Current Zoning: IC-1 (institutional campus) and R-12MF(CD) (multi-family residential, conditional)
Proposed Zoning: R-12MF(CD) (multi-family residential, conditional) and R-12MF(CD) SPA (multi-family residential, conditional, site plan amendment)

Approximately 3.9 acres located on the north side of Albemarle Road, west of Harrisburg Road, and south of Pence Road.

The petition proposes to allow up to 47 single family attached residential (townhome) units on a vacant parcel located north of Albemarle Road and west of Circumferential Road.

STAFF RECOMMENDATION

<p>Issue Date: 12-21-22</p>	No.	Date	Description	1	7/14/23		2	5-25-23		3	3-10-23		4	1-10-23		<p>Sheet 1 of 1</p>	<p>Project Number: 199.005</p>
No.	Date	Description																
1	7/14/23																	
2	5-25-23																	
3	3-10-23																	
4	1-10-23

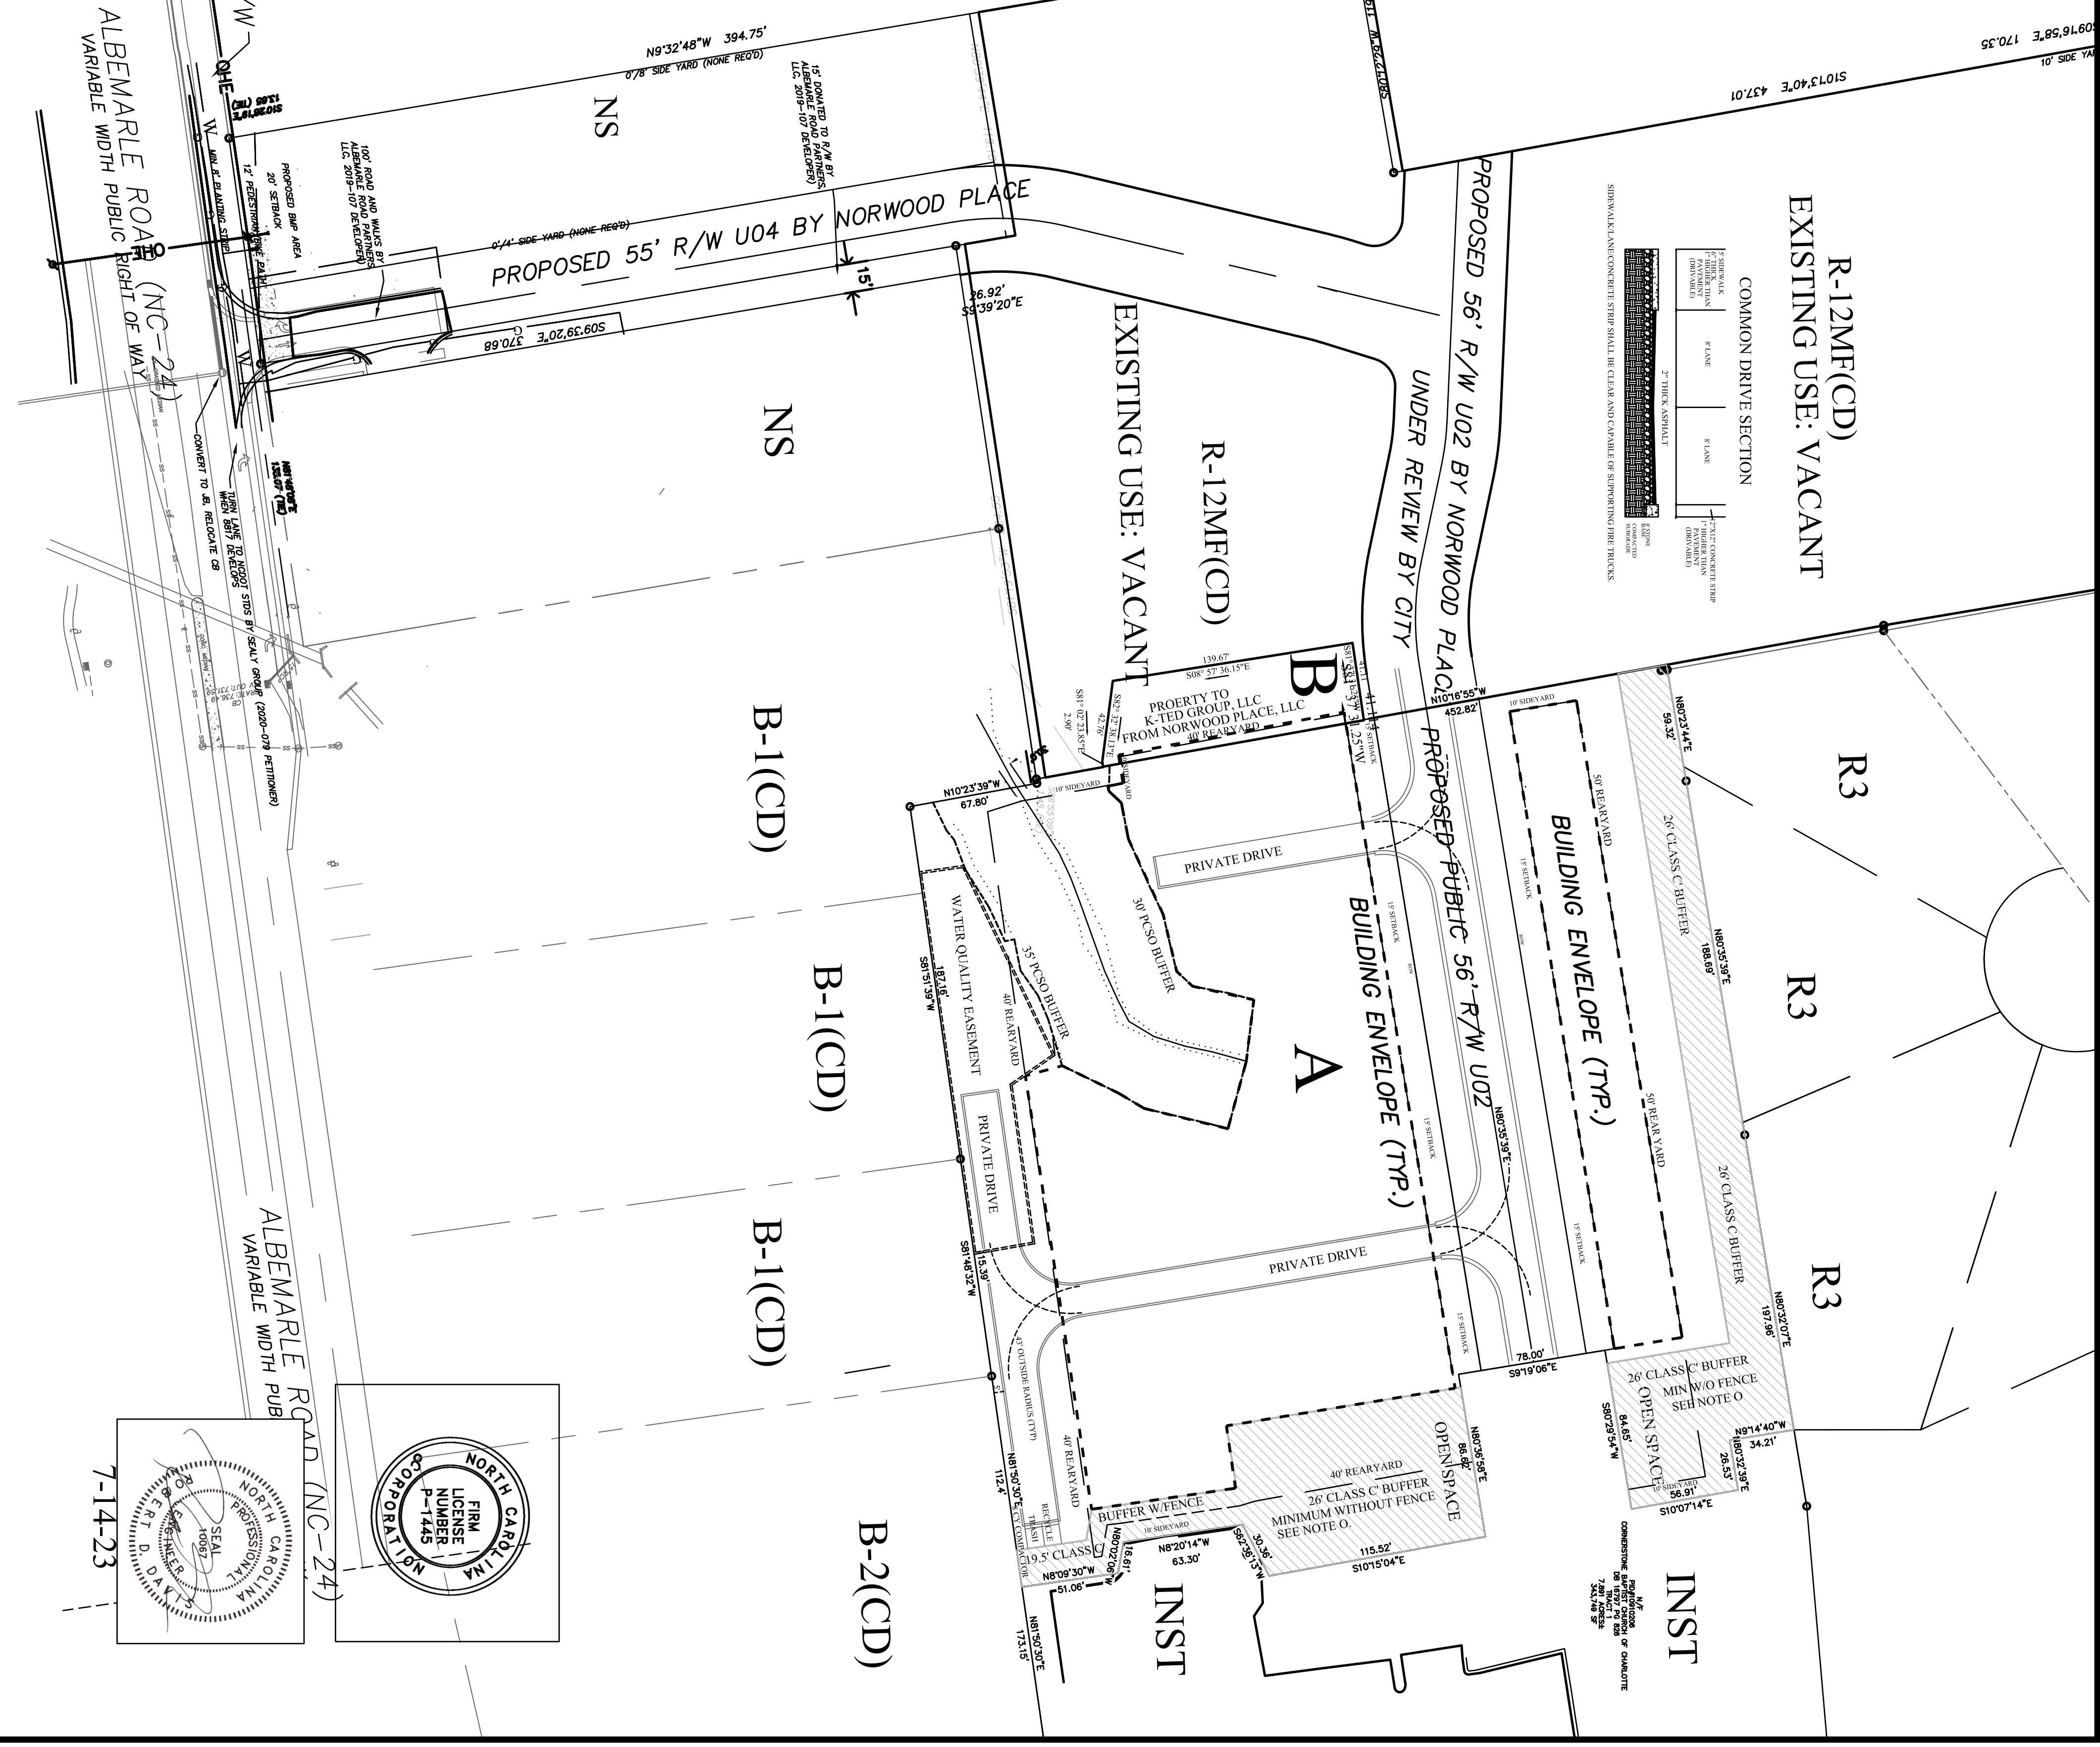
5. Site must show a minimum of 15% of the overall site as tree save. This requirement must be shown on the site plan.
6. **New Outstanding Comment resulting from most recent site plan:** Remove notes under Environmental Features as marked up. Please include notes from previous versions of the rezoning plan (see ACCELA):

- a. The petitioner shall comply with the Charlotte City Council Approved and Adopted Post-Construction Stormwater Regulations.
 - b. The location, size, and type of stormwater management systems depicted on the rezoning plan are subject to review and approval as part of the full development plan submittal and are not implicitly approved with this rezoning. Adjustments may be necessary in order to accommodate actual storm water treatment requirements and natural site discharge points.

- c. Development within any SWIM/PCSO Buffer shall be coordinated with and subject to approval by Charlotte-Mecklenburg Stormwater Services and mitigated if required by ordinance. Stream delineation reports are subject to review and approval by Charlotte Storm Water Services.

7. Please provide architectural standards as listed on previous version of site plan.
